Comments re planning application 2024/92063

An Objection

Development Plan

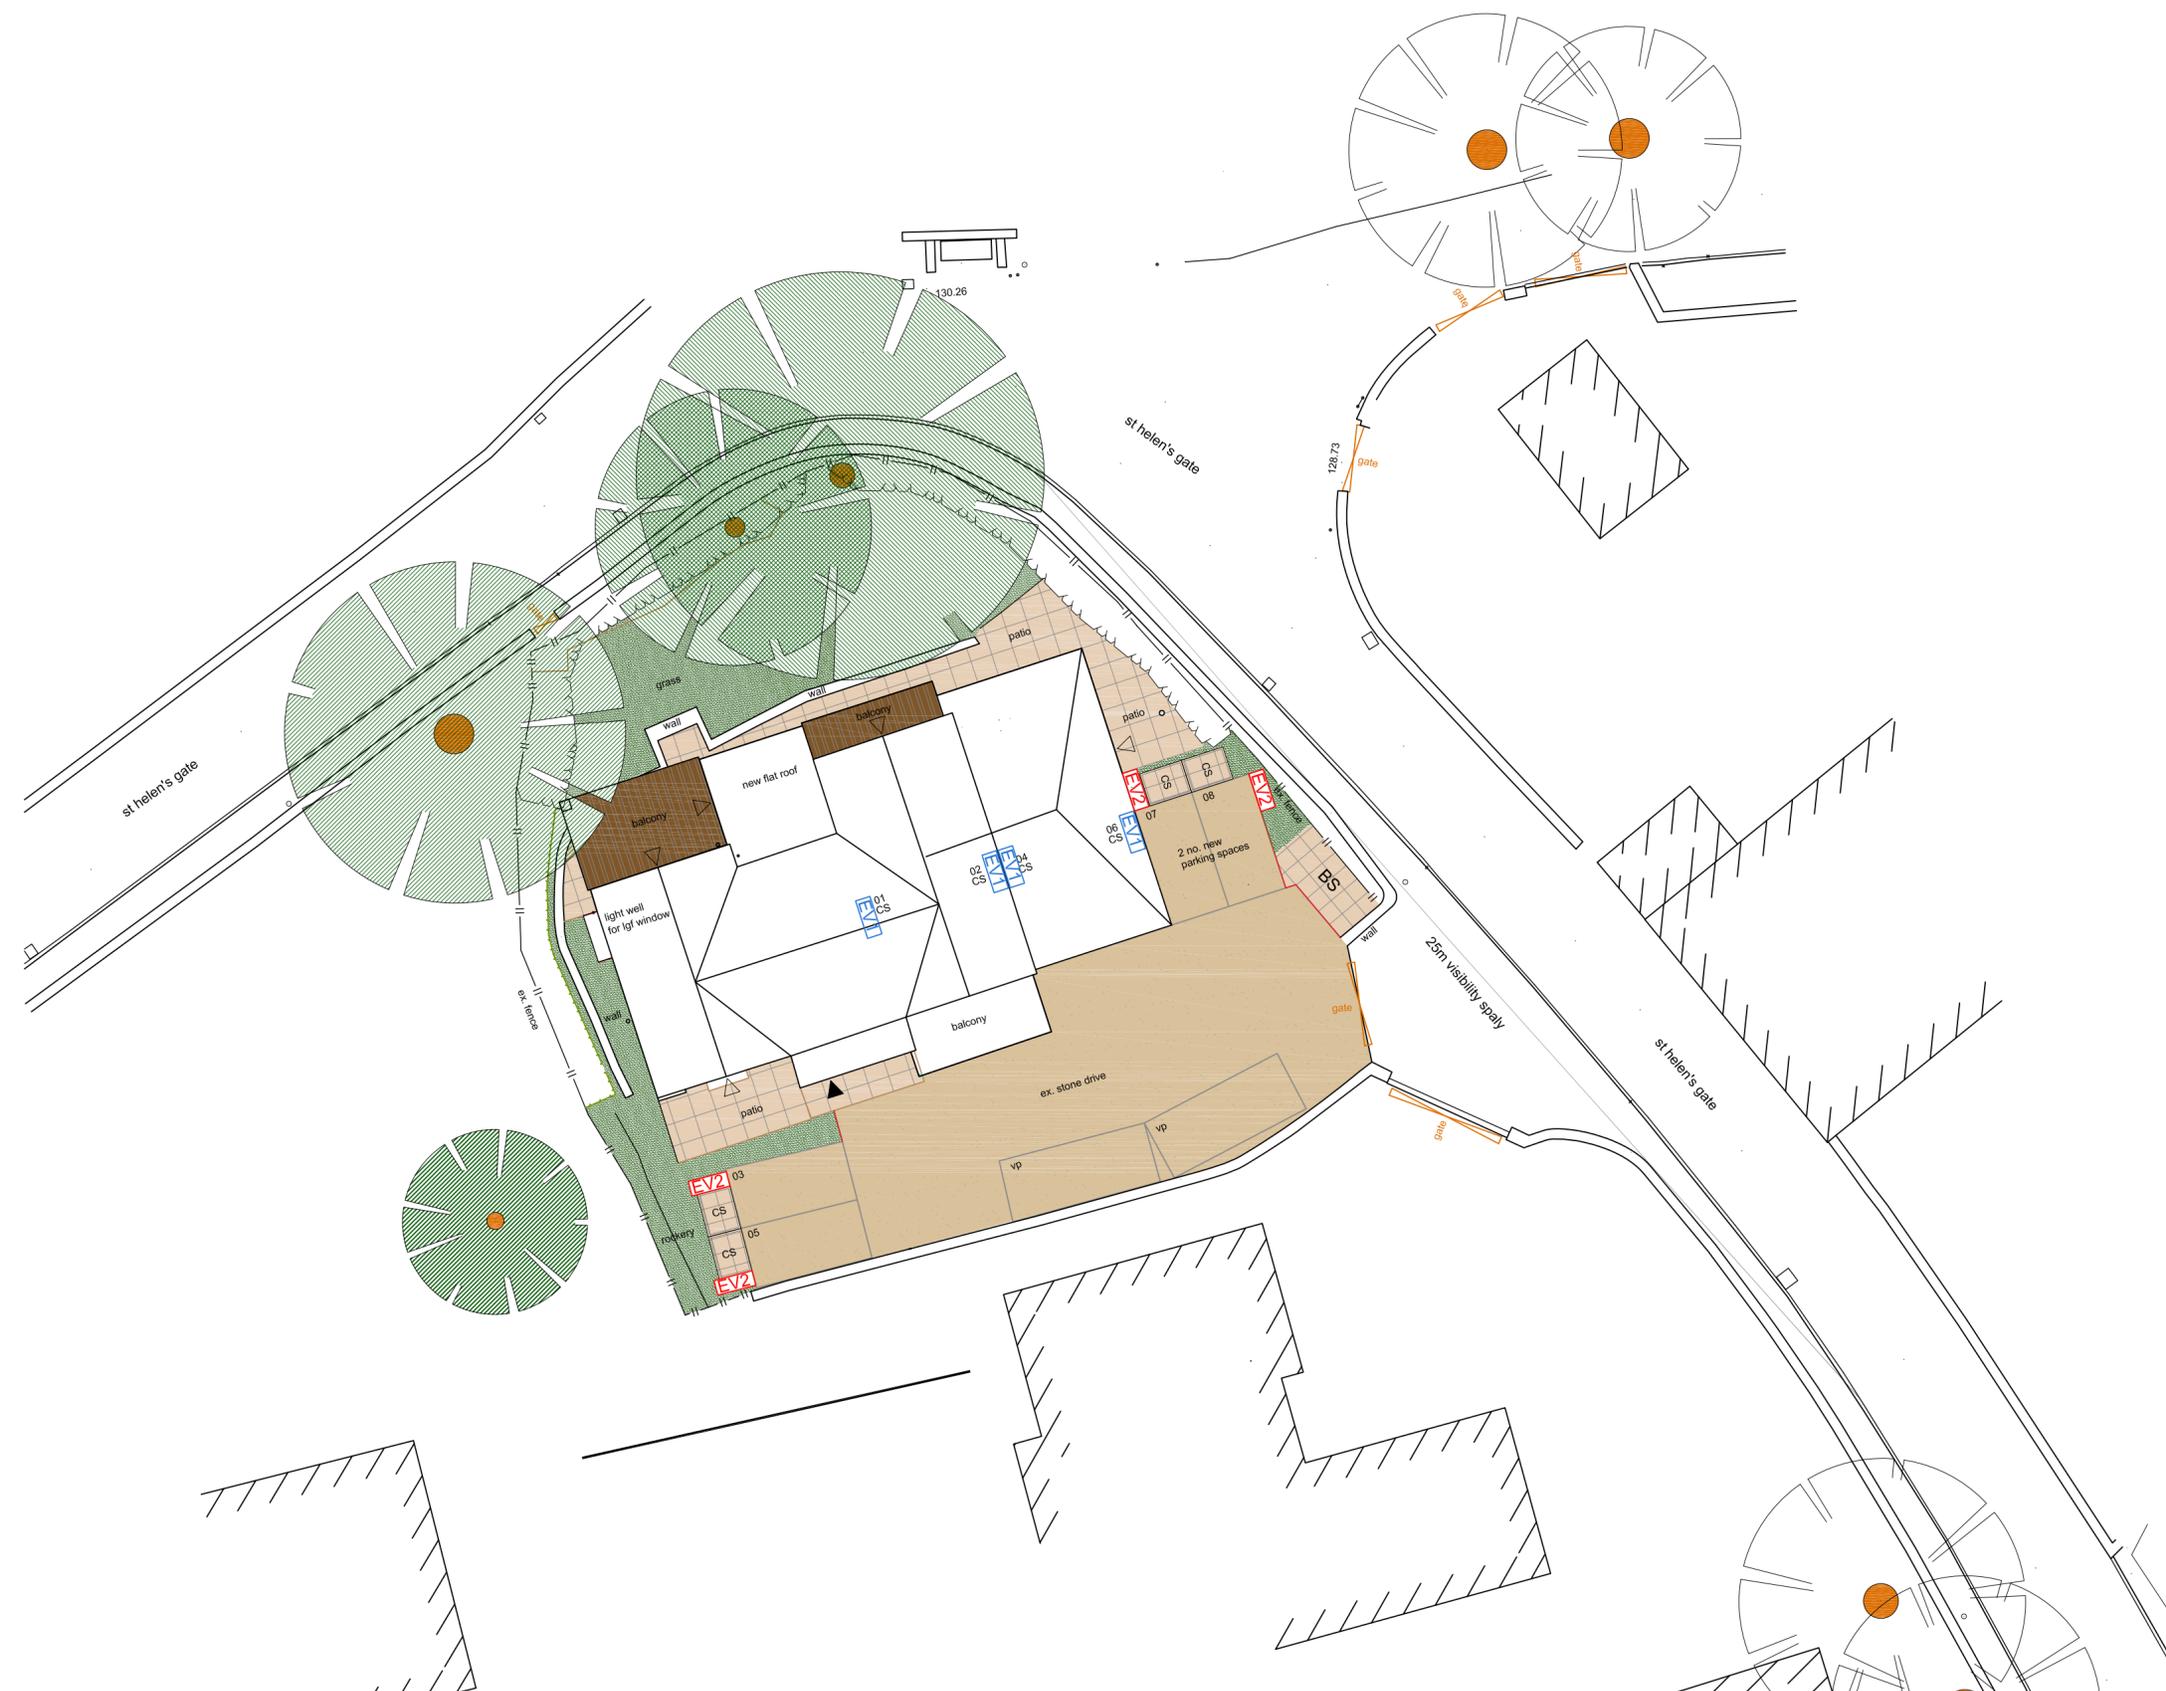
- ii. Access to both lower ground floor apartments are via the same car port for both of these properties. This also means this car port cannot be used for parking as will restrict access to the apartments by residents and emergency services.

- k. Ground floor apartment (south east) has no designated living space.
- l. Parking
- i. Not enough car parking spaces for number of apartments as it is likely most if not all apartments could have 2 or more people living there as mainly 2 bed apartments. This equates for over 18 people residing and most people have a car each. Also see comment 2.i.ii above.

- ii. Not enough turning space for vehicles to safely exit the site.
- iii. No space for visiting vehicles to park off road. This is not safe as there is nowhere else safe to park for either residents or visitors on St Helen's Gate or Dark Lane.
